CITY OF ALBUQUERQUE

RE: **RMCI Office & Shop**
5440 Watson Dr SE
Grading and Drainage Plan Stamp Date: 2/14/20
Hydrology File: Q16D007

Based on the submittal received on 2/25/20, the above-referenced Grading and Drainage Plan cannot be approved until the following corrections are made:

ROUGH  
GRADING  
PLAN  
&  
DRAINAGE  
ANALYSIS

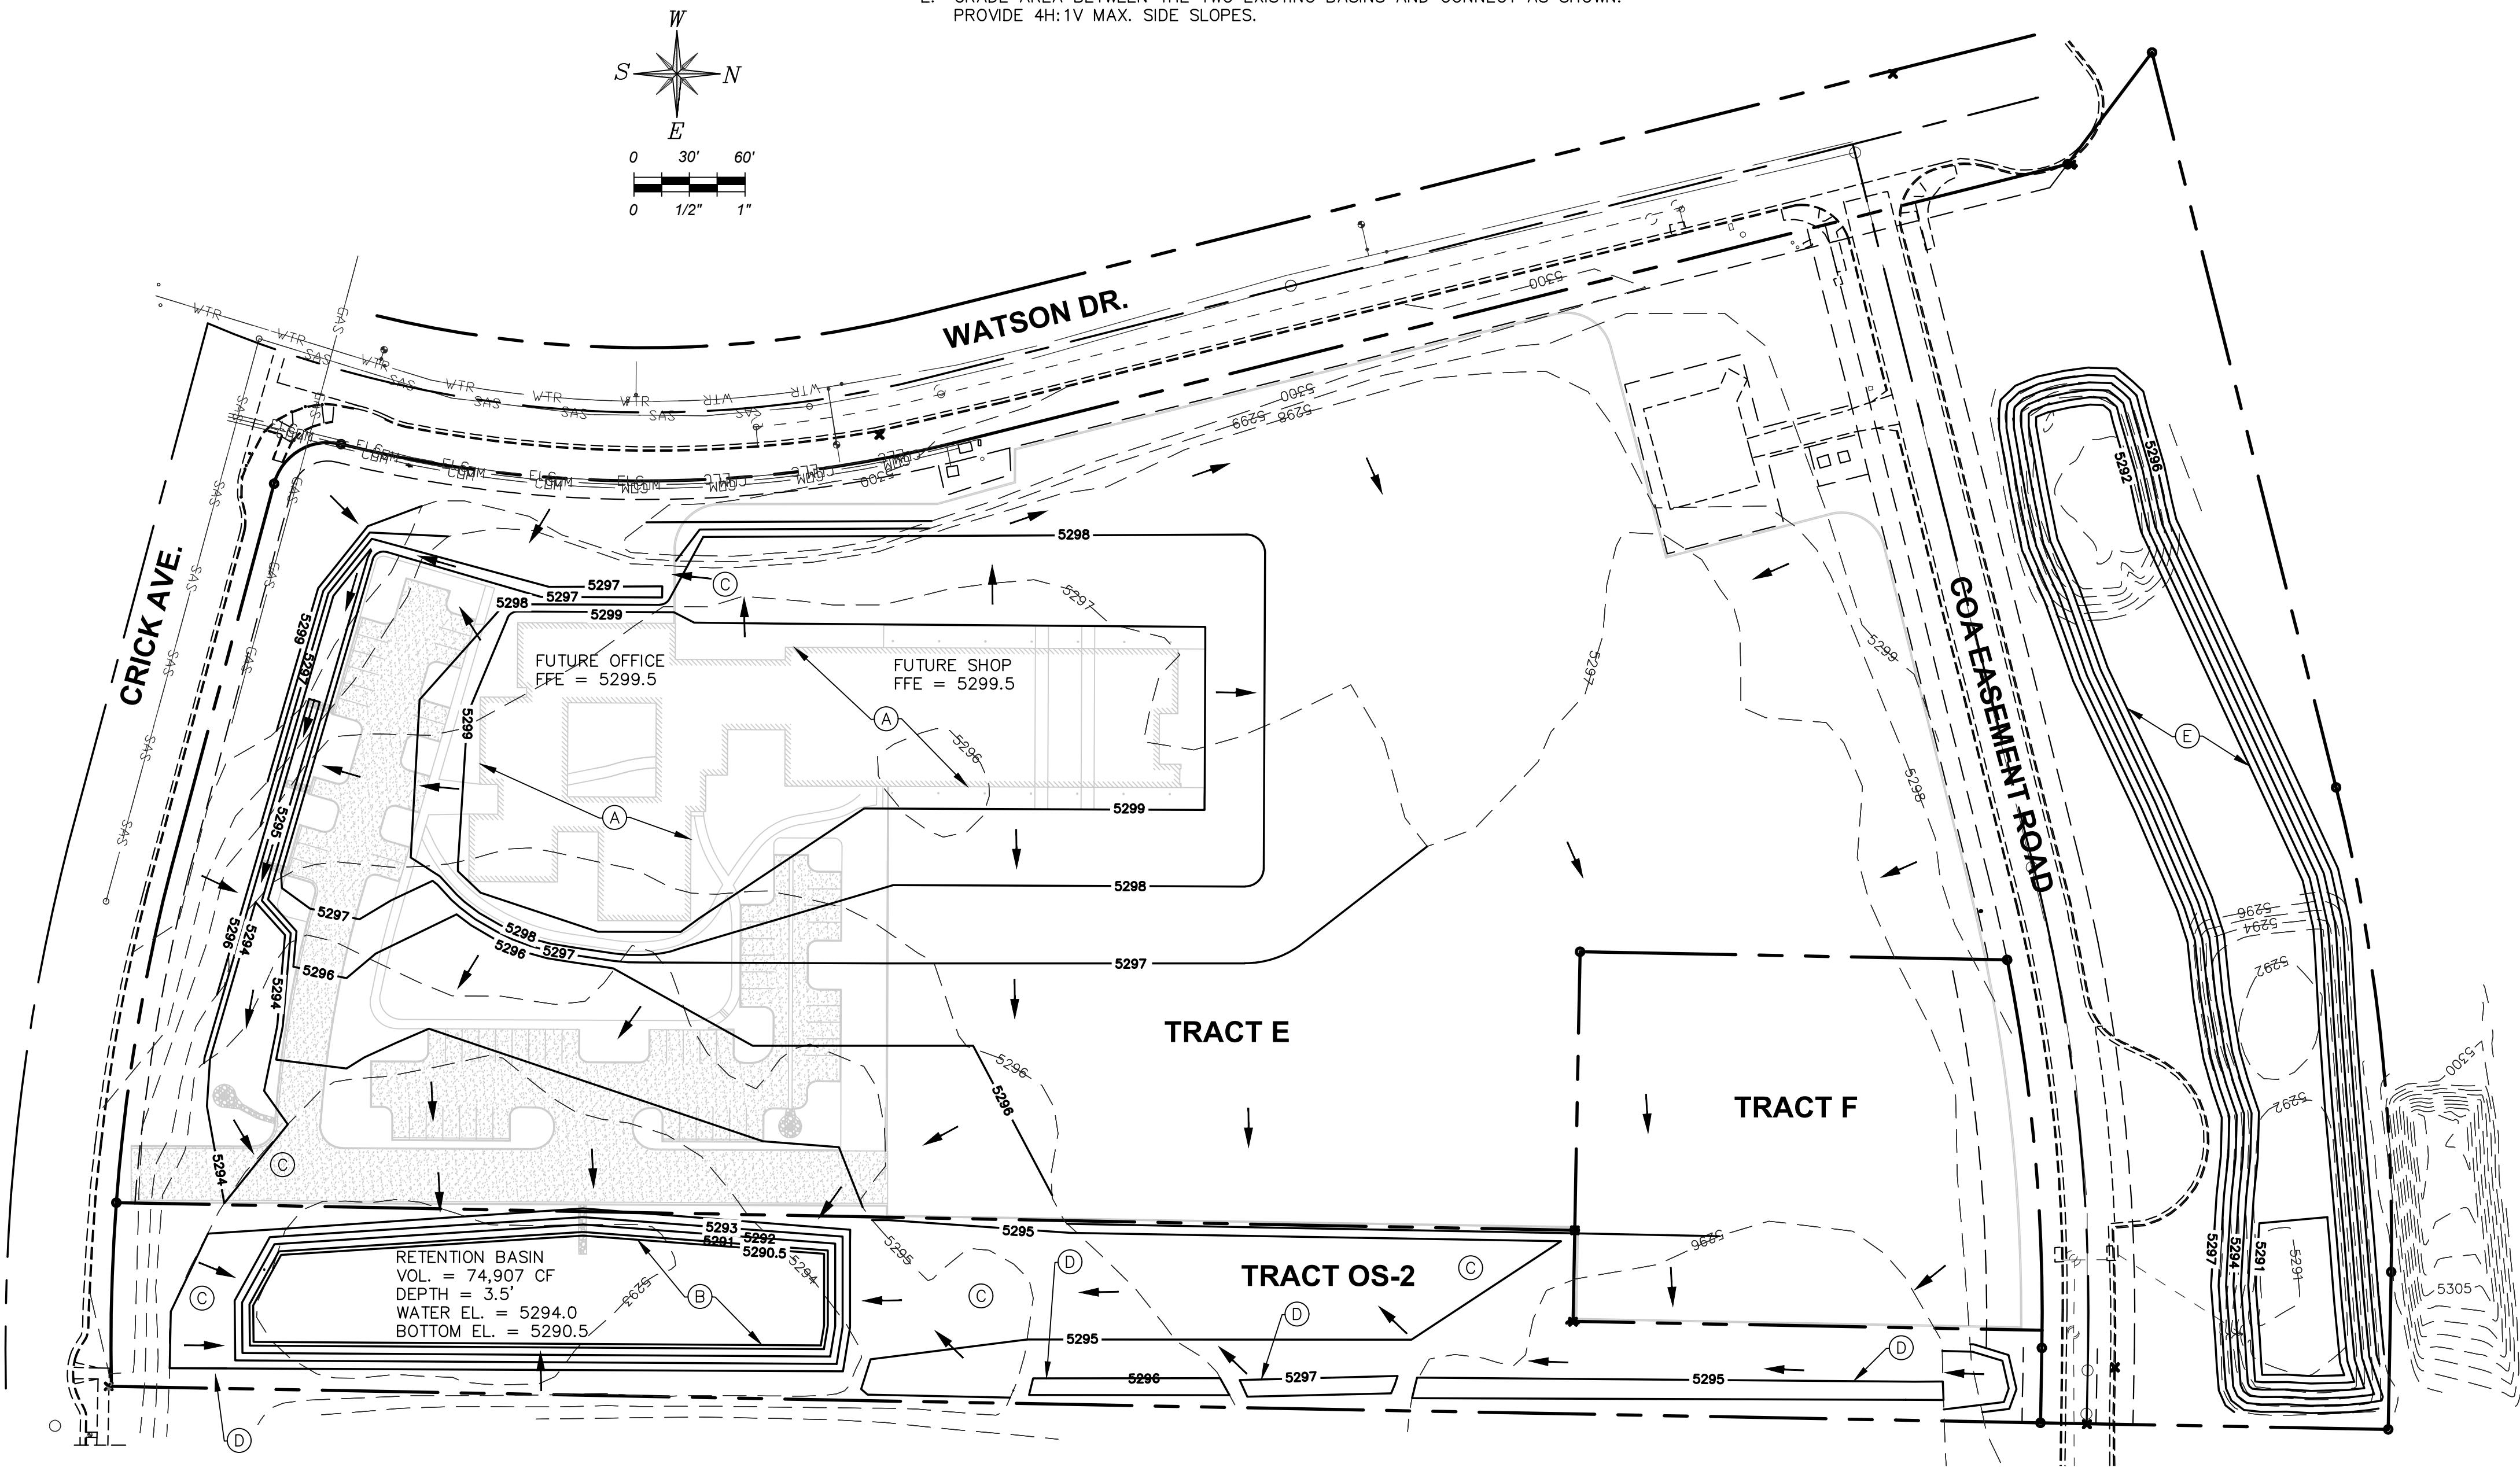
3. Each sheet needs to be stamped and signed.
4. Remove the extraneous existing spot elevations, so the significant ones can be read.
5. The Drainage Analysis needs to be updated to include the addition of the buildings. This includes basin delineations and Hydrology calculations, Hydraulic calculations, and pond sizing. It will also need to demonstrate compliance with the approved Master Plan (BHI, 2008).

6. The site must demonstrate adequate downstream capacity per § 14-5-2-12(G) of the Albuquerque Code of Ordinances.
7. Provide management onsite for the Stormwater Quality Volume (SWQV) in accordance with the new drainage ordinance, § 14-5-2-6 (H) enacted 10/2/18 (Council Bill C/S O-18-2). To calculate the required volume to be captured, multiply the impervious area (SF) by 0.34 inches for the 90th percentile storm.
